Appeal Decision

Appeal Ref: APP/Z4718/W/25/3369792

42 Daisy Hill, Dewsbury WF13 1LH

- The appeal is made under section 78 of the Town and Country Planning Act 1990 (as amended) against a refusal to grant planning permission.
 - The appeal is made by Mr Masum Karolia against the decision of Kirklees Metropolitan Council.
 - The application Ref is 2025/62/90365/E.
 - The development is the proposed change of use of retail space to one bed flat.
-

PROPOSED FRONT ELEVATION

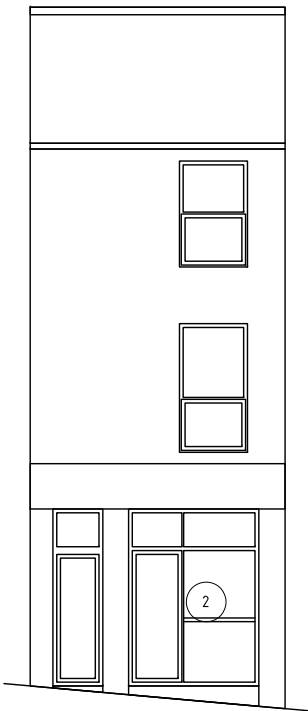
14. The proposed new window facing towards Daisy Hill would be large, but no daylight assessment has been provided to demonstrate future occupiers would receive adequate light to the proposed accommodation. In view of the size and diagonal shape of the living space, and the position of surrounding buildings, it would likely receive limited natural light into the inner parts of the room where the kitchen and dining space are shown to be, which would likely require artificial light and create harmful living conditions for future occupiers. In view of my findings above, its dual aspect would not off-set this identified harm. Whilst the appellant has indicated that they are willing to amend the layout, no amendments have been provided.

15. There are pavements to either side of Daisy Hill, along with a central carriageway. I saw that the road was regularly used by pedestrians, and although only a snapshot in time during the middle of the day, I did not observe that it was particularly busy, perhaps reflecting its distance from the main commercial areas of the town centre. It is acknowledged that pedestrians could directly pass in front of the proposed new window on the appeal property and the window would be level with most head heights. Nevertheless, this would likely be for a very short duration, and those passing by would likely be facing away from the window in question as they walked or cycled passed it.

PROPOSED GROUND FLOOR PLAN

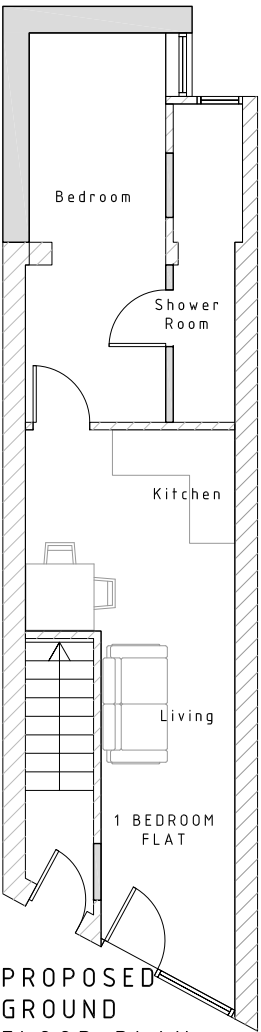
12. The proposed one-bedroom flat would have a door and window facing onto Daisy Hill serving its shared living space, it would also have a window to the rear side serving a bedroom. On the opposite side of the road is no's 47-51 Daisy Hill, which is understood to have a commercial use and openings at ground floor level, although its shutters were closed at the time of my site inspection, which indicated to me it was not currently operational, it is said to be some 8.5 metres at its closest to the appeal property.

13. The proposed bedroom window would be to the side, near to the end of the room and face into a small courtyard close to other buildings, which would mean the outlook and natural light from that window would likely be very restricted and harmful to the living conditions of its future occupiers. As a result, there could also be a need for more artificial light into the bedroom, without a daylight assessment I cannot be certain it would receive adequate light to the whole of the bedroom. To the front elevation, the outlook from the single window would be dominated by the row of tall buildings opposite, which would also harm the outlook for future occupiers of the proposed flat, who would likely feel significantly enclosed to both the front and rear sides. Given its ground floor location within the town centre, it is also accepted that future occupiers may choose to use blinds or other privacy measures, which would likely add to the poor outlook from its living space.
